From: [REDACTED]
Sent: 17 March 2021 09:20
To: Amber Willard
Cc: [REDACTED]
Subject: RE: fp/18/21/hh

I am just writing up your application at Sea Drive, FP/18/21/HH.

DRAWING
**PROPOSED
ELEVATIONS**
DRAWING No
331/05
REVISION
SCALE 1:100
DATE JAN 2021
DRAWN LA
CHECKED

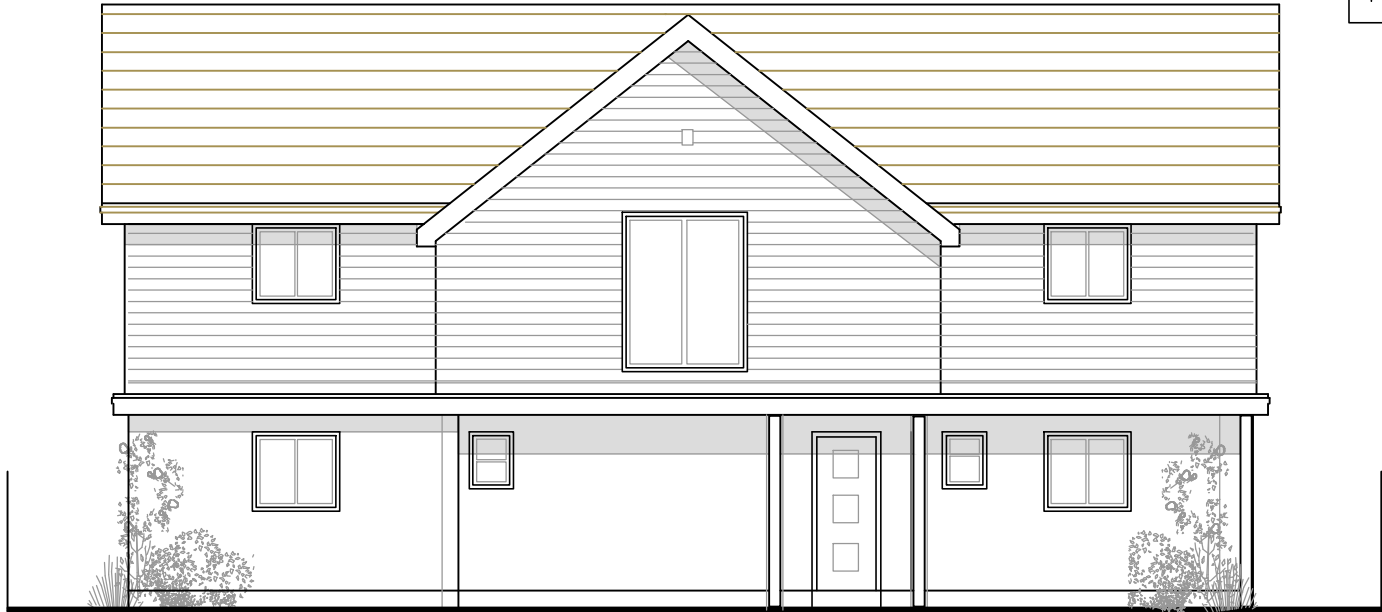
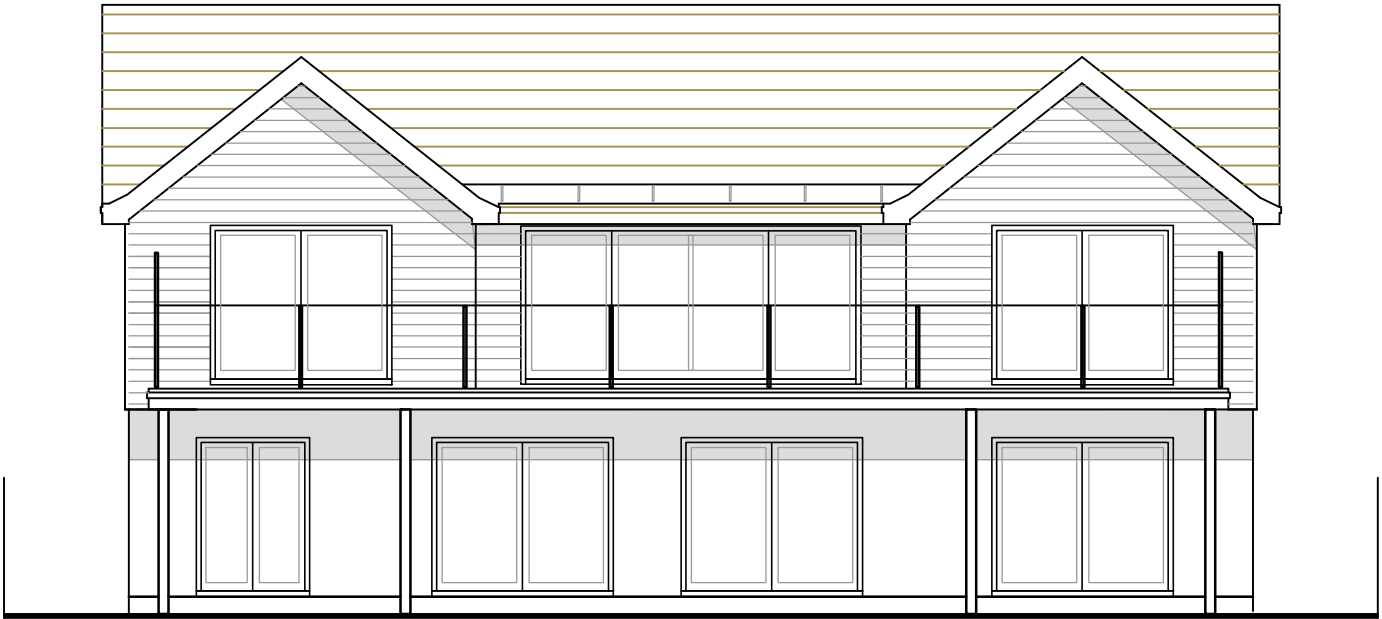
I am writing to see if you know the colour of the cladding that is proposed, otherwise details may have to be submitted via condition.

The cladding colour will be Cedral Dark Grey.
